SSD-3846-Mod-1 RE 1 West Culburra Mixed Use Subdivision (WH8)

I refer to the Department's email of 20 August 2025 regarding State Significant Development SSD-3846-Mod-1 West Culburra Mixed Use Subdivision – Modification 1 – Realign development footprint for 'Minor re-orientation of the development footprint to align with a recent survey of the Mean High Water Mark (MHW). The modification also removes the detailed lot layout from the concept plan and amends the stormwater basins' at Culburra Road, Culburra Beach (Lot 1 DP 1305809) in the Shoalhaven City Council local government area (LGA). Submissions need to be made to the Department by 4 September 2025.

SITE LAYOUT PLAN
SCALE 1:4000

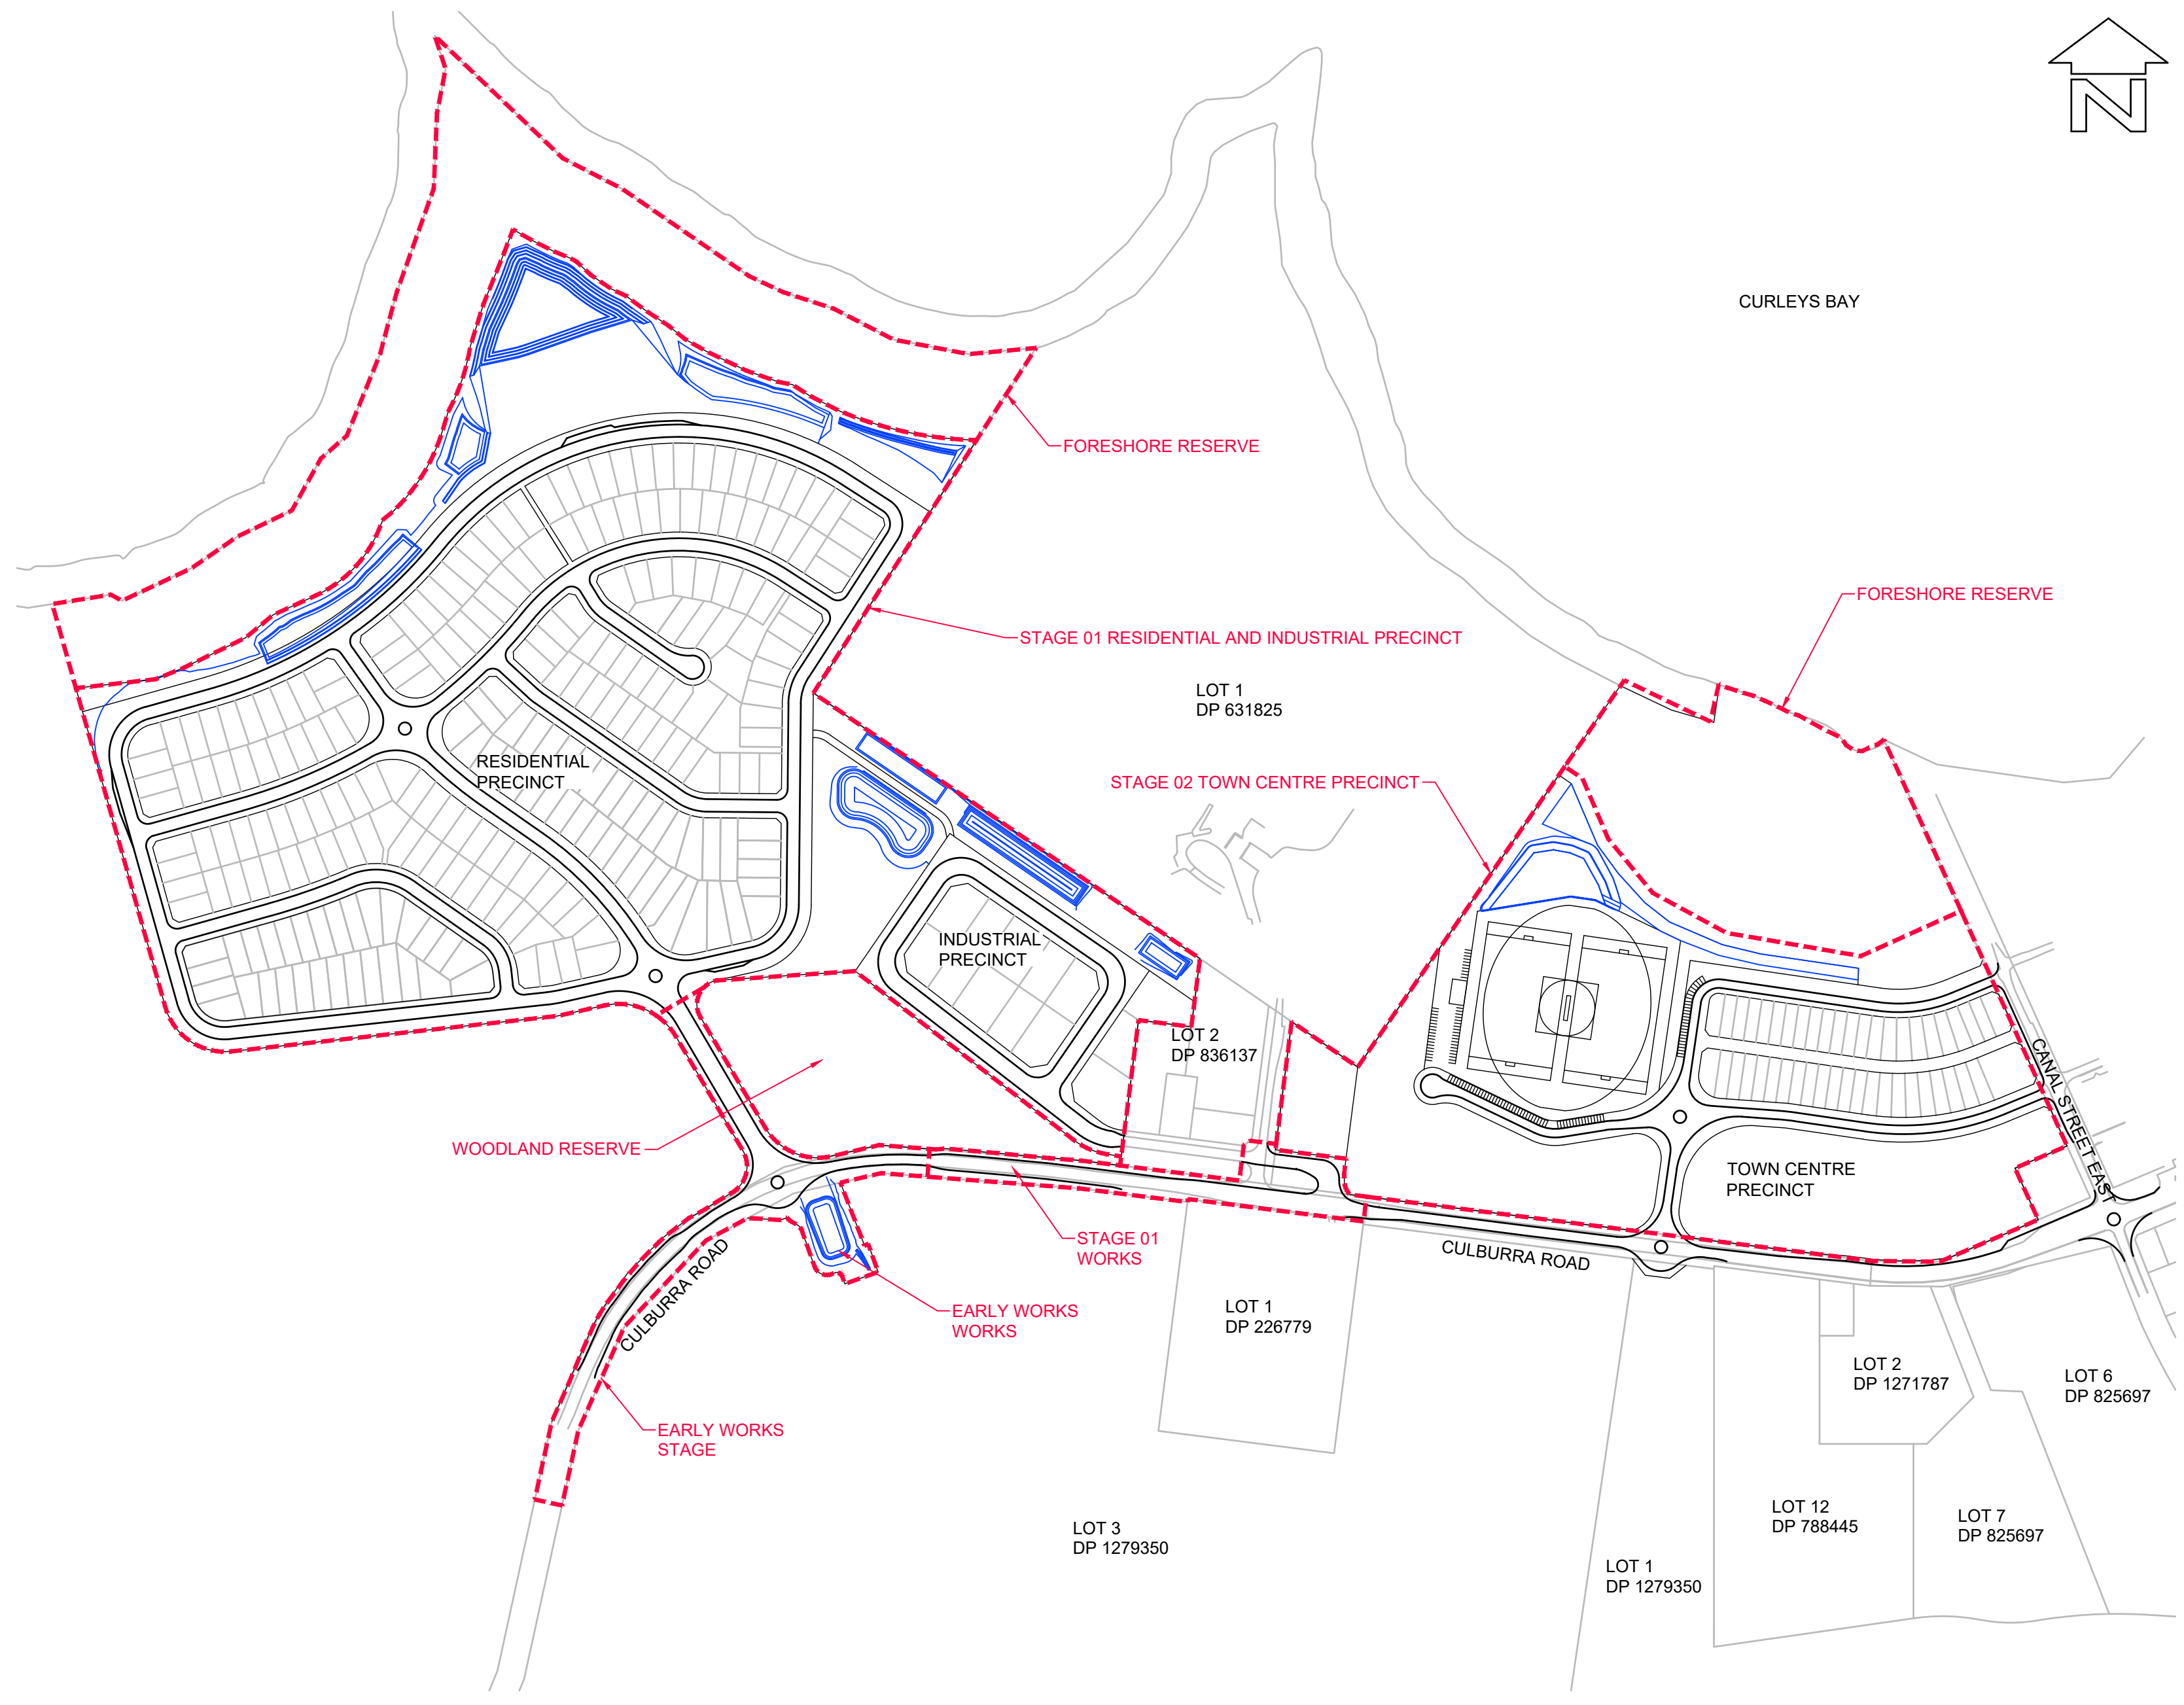
The below copy of the Proposed Mixed Use Concept Plan does not appear to show provision / identify the new zone substation site.
